From: [Jeremy Larson](#)
To: [Chace Pedersen](#)
Subject: RE: VA-24-00002 Dunckley - Notice of Application
Date: Friday, October 18, 2024 4:16:16 PM
Attachments: [R302.1 Fire Separation with Commentary Figures.pdf](#)

Thank you for the opportunity to provide comment on this application. A building permit will be required to remodel the structure and bring it into compliance with current building codes. Due to the high snow load at the parcel, building plans will be required to be prepared and stamped by a Washington State licensed architect or engineer.

## EXHIBIT MAP

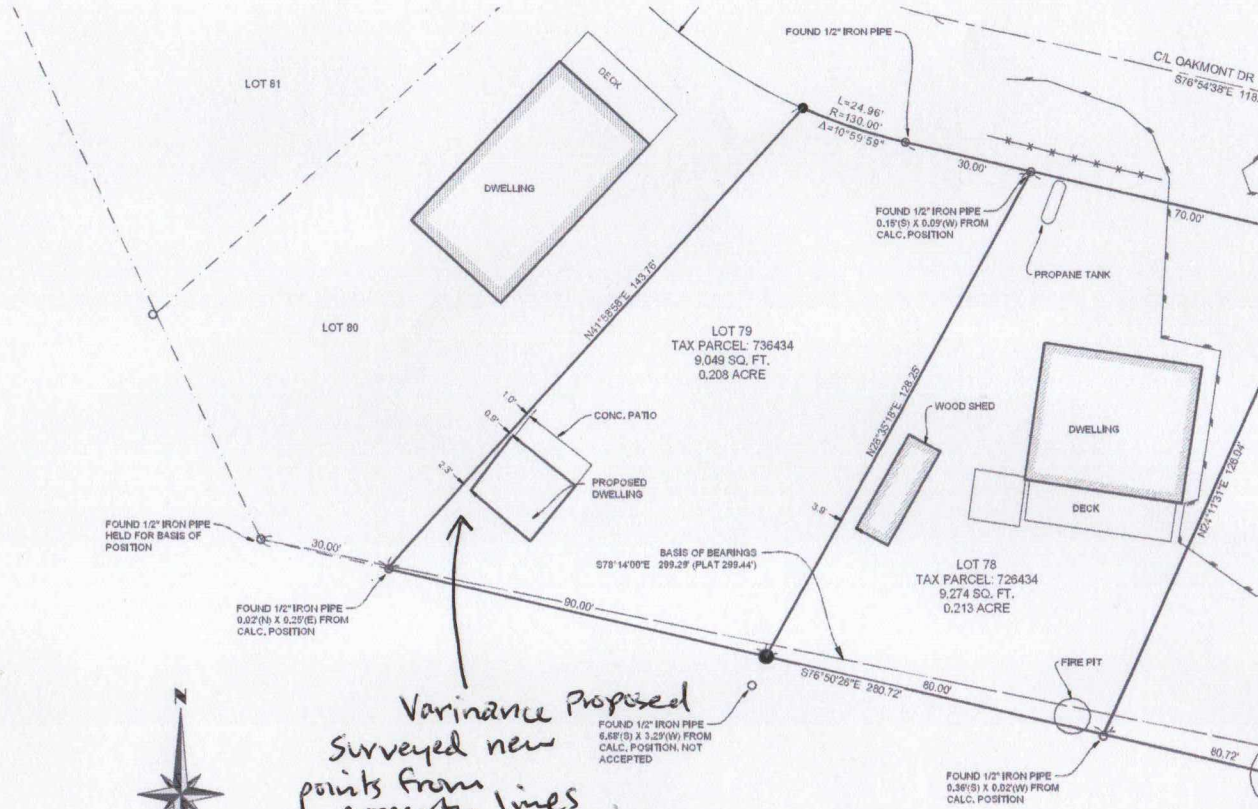
Due to the close proximity to the property line, additional fire separation is required. Openings in walls are not allowed if the property line is less than 3 feet from an exterior wall. Roof overhangs or any projections are not allowed less than 2 feet from a property line. Additional fire resistance rated construction is required for walls that are less than 5 feet from a property line or less than 3 feet if the structure has an automatic sprinkler system.
